Outdoor seating area on pavement consisting of 2 No. tables & 4 No. chairs to be stored when not in use.

Andalucia Restaurant 58 Ferring Street Ferring

Thank you for your internet representation made on 4th October 2018 which has been recorded as '**an objection**' with the comments as follows:

PROJECT	RESTAURANTE ANDALUCIA 58-60 Ferring Street, Ferring BNT2 5JP		
TITLE			
PROPOSED CHANGE OF USE AND TABLES AND CHAIRS LICENSE			
DRAWN	DATE	SCALE	CHECKED
RM	August 2018	shown	
PROJECT	NUMBER		REVISION
BD 18114	09-01		-

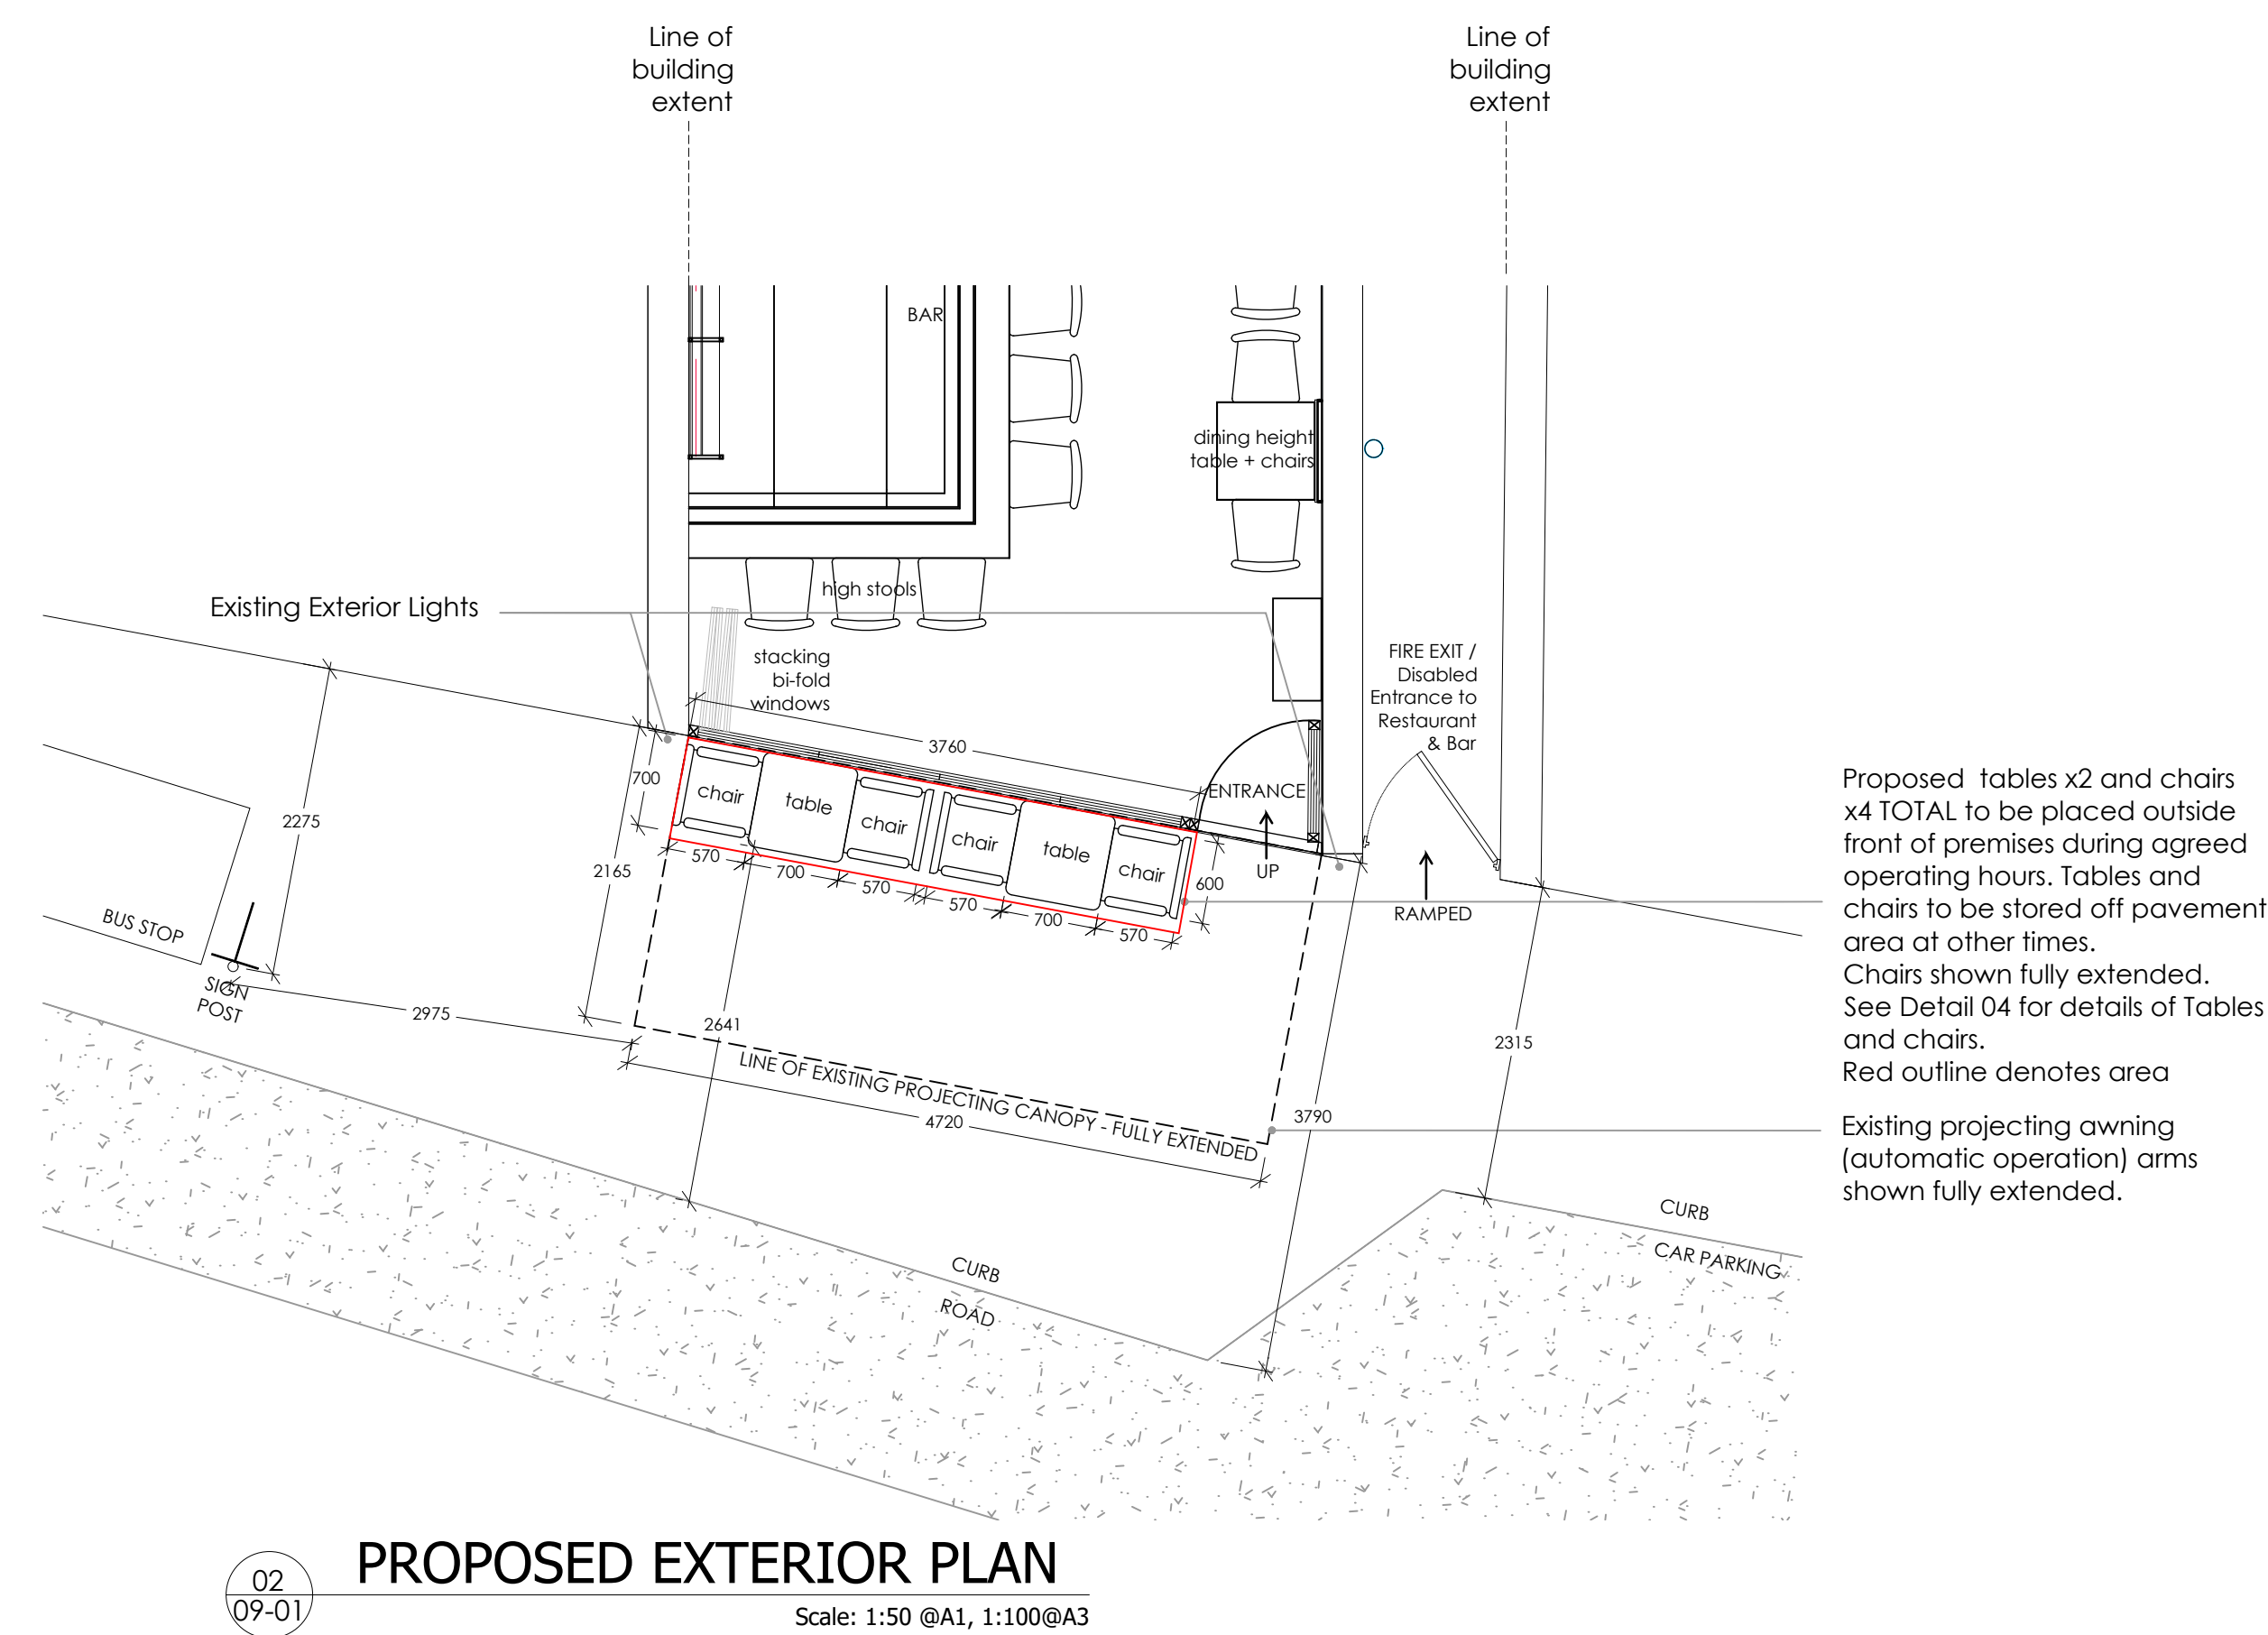
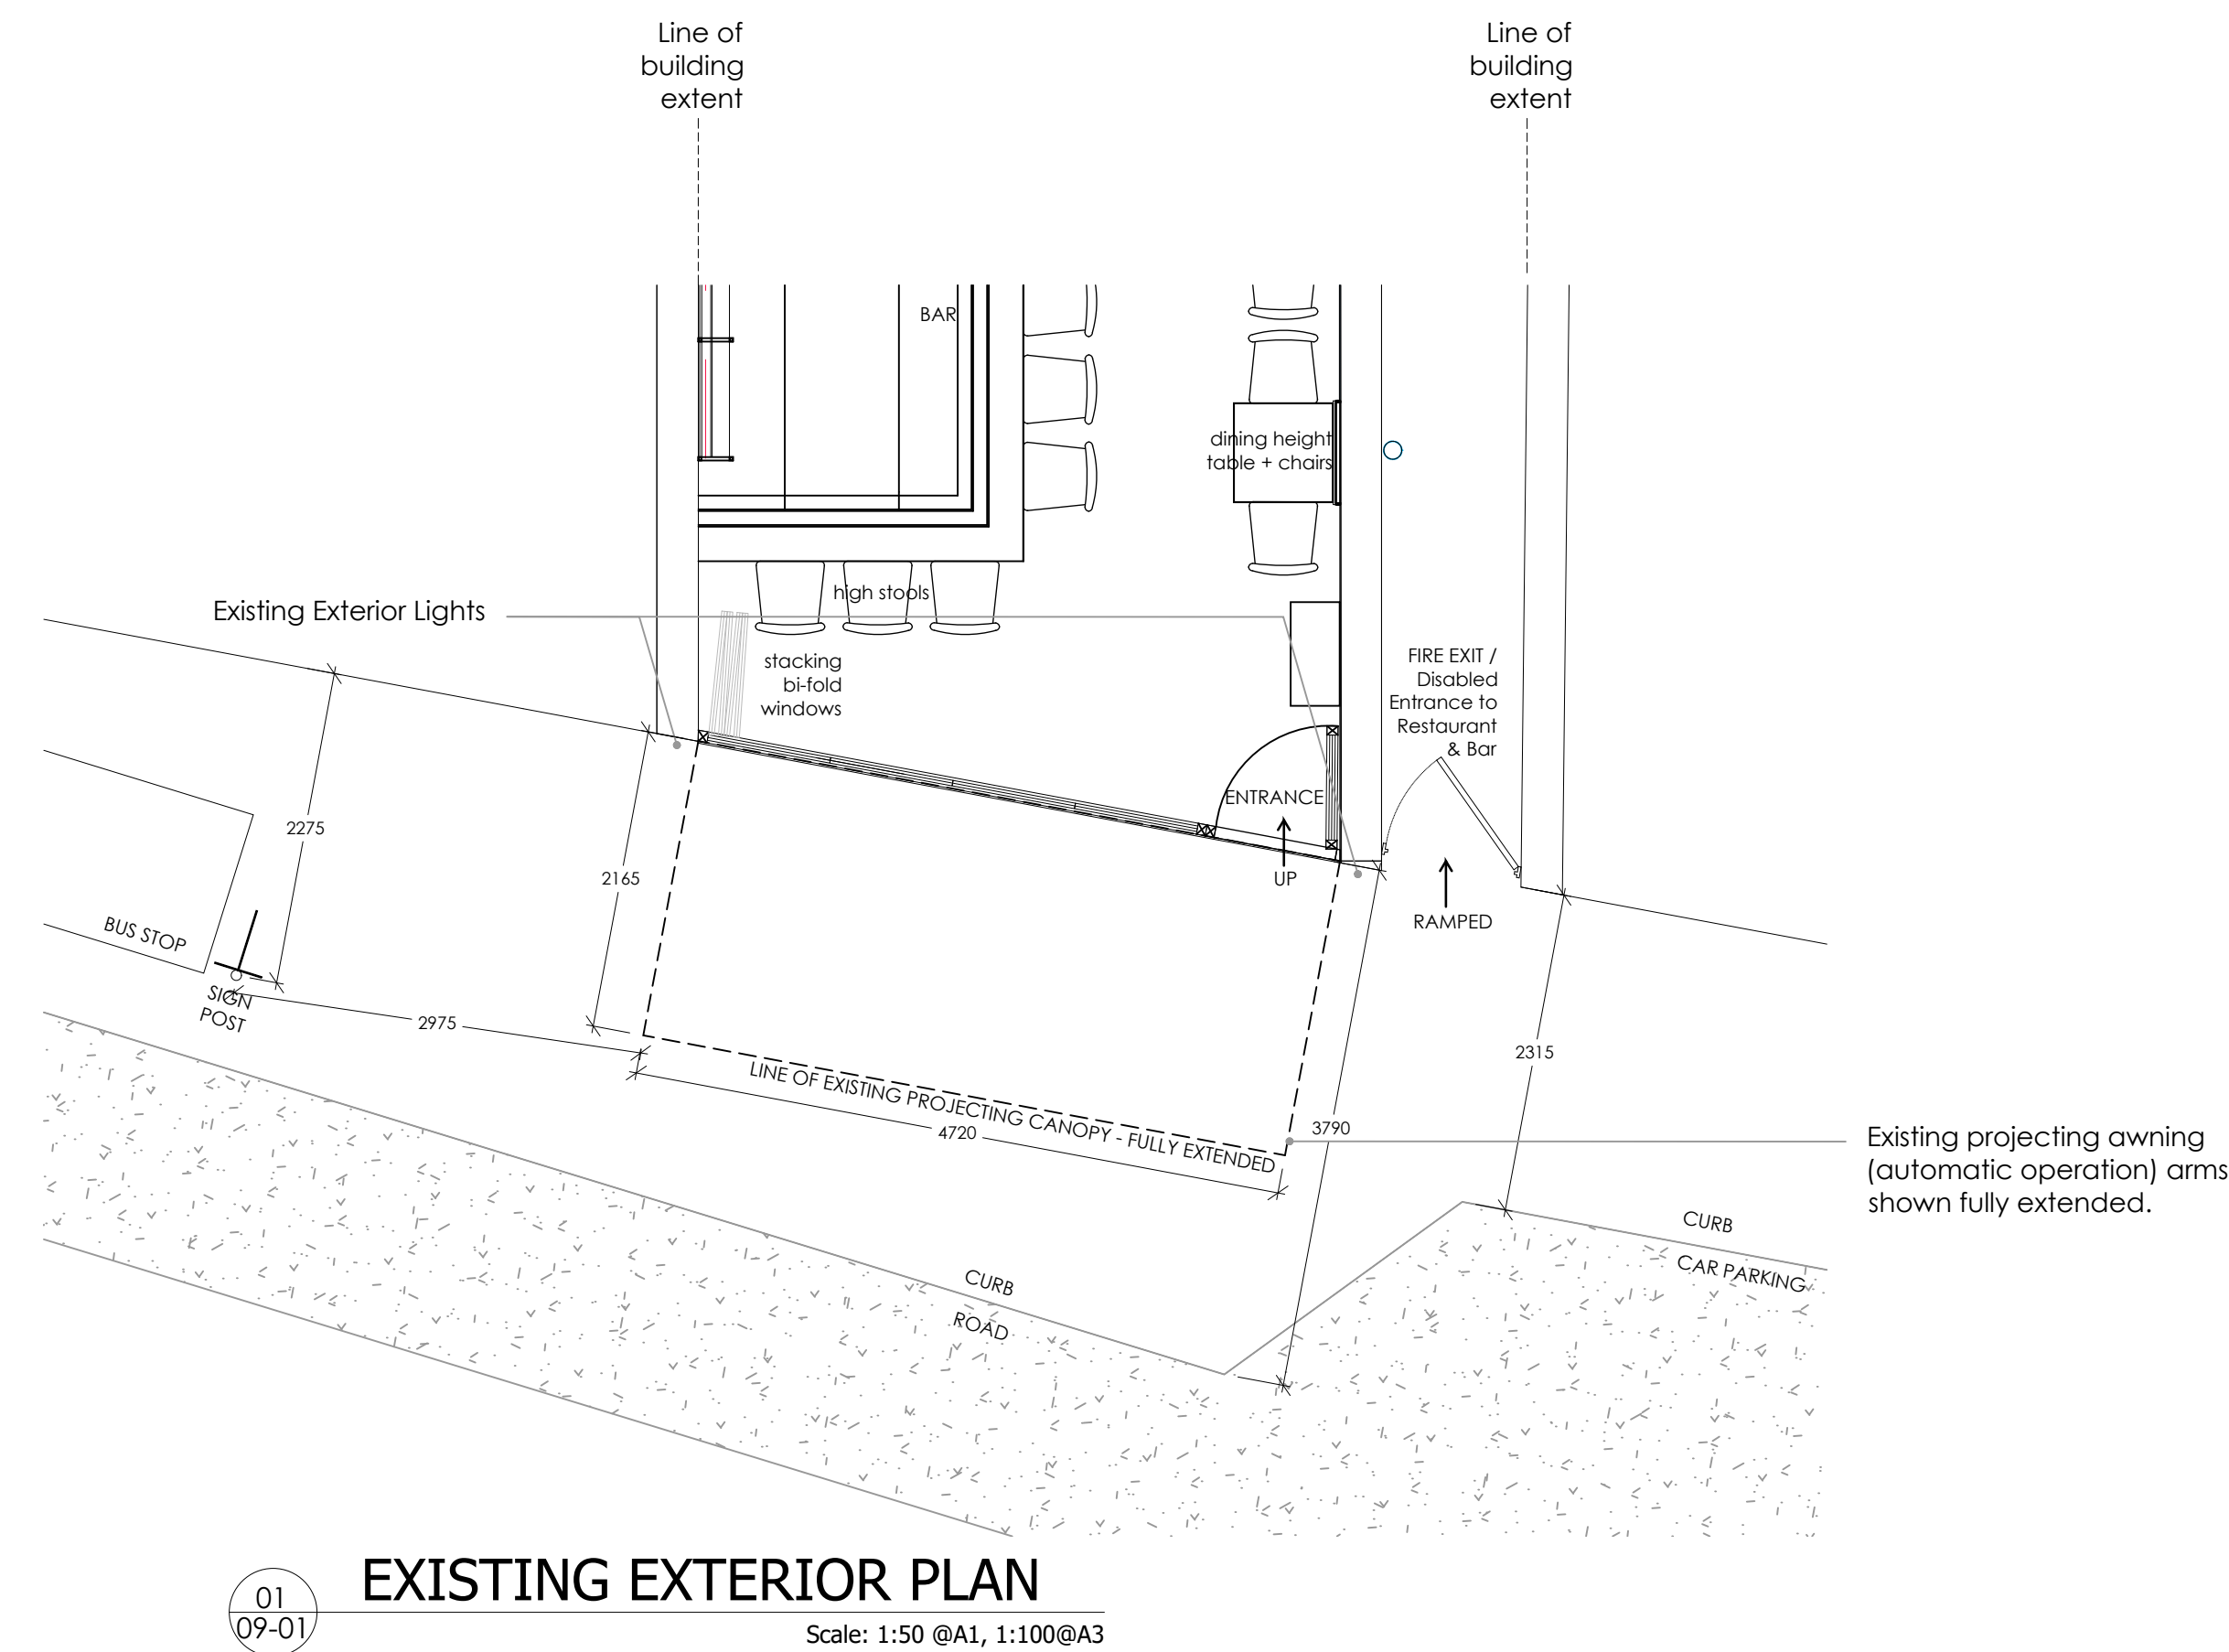
Ferring Conservation group objects to this application. Placing tables on a narrow pavement, very close to a bus stop, will create obstructions for pedestrians, wheelchairs and other pavement traffic.
